Application number: 2024/93055	
What is the application for?:	Erection of detached dwelling and associated external works
Address of the site or building:	Land Adj, 2, Hopton Hall Lane, Upper Hopton, Mirfield, WF14 8EP
Postcode:	WF14 8EP

User comments

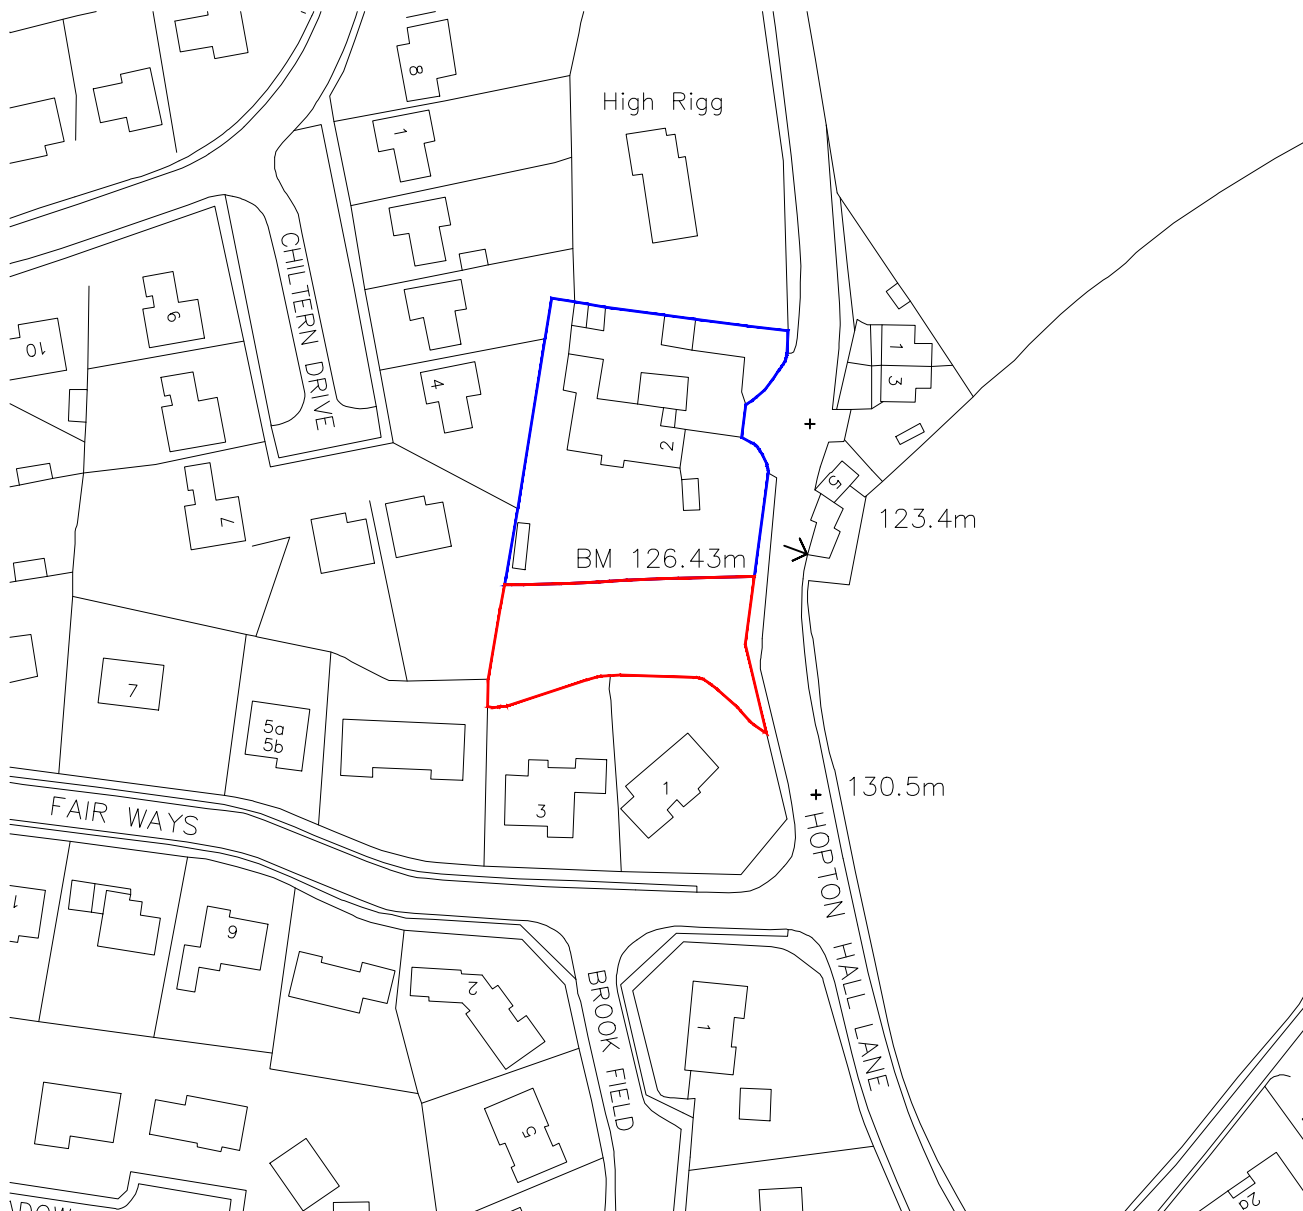
Type of comment: An objection	
Do you wish your comments to be published on the website anonymously?	<input type="checkbox"/> Yes
<p>1) The proposed plans show that the new building will be very close to the boundary between our garden and the side of the house.</p> <p>2) The six windows on the top floor over the courtyard will directly overlook our house and garden, giving views directly into all our back rooms, resulting in a significant loss of privacy.</p> <p>3) These windows will also directly overlook our back garden again with a significant loss of privacy.</p> <p>4) The proposed building is significantly larger than others directly surrounding it, or in the local area, and is also out of character with those buildings in its design and construction.</p> <p>5) There is no mention about plans to change the existing established hawthorn hedge separating the development and the garden of 5 Chiltern Drive. Is it intended to keep this hedge.</p> <p>6) The proposed entrance to the property is directly onto the very busy Hopton Hall Lane, very close to a blind narrow band, and will be a significant hazard.</p> <p>7) Will this application be considered in open chamber by the Planning Committee? If so, I wish to attend so please advise me of the hearing date and location etc.</p> <p>8) I request that my address is not published due to the proximity of my property and the proposed building and my understanding that approaches from other villagers</p>
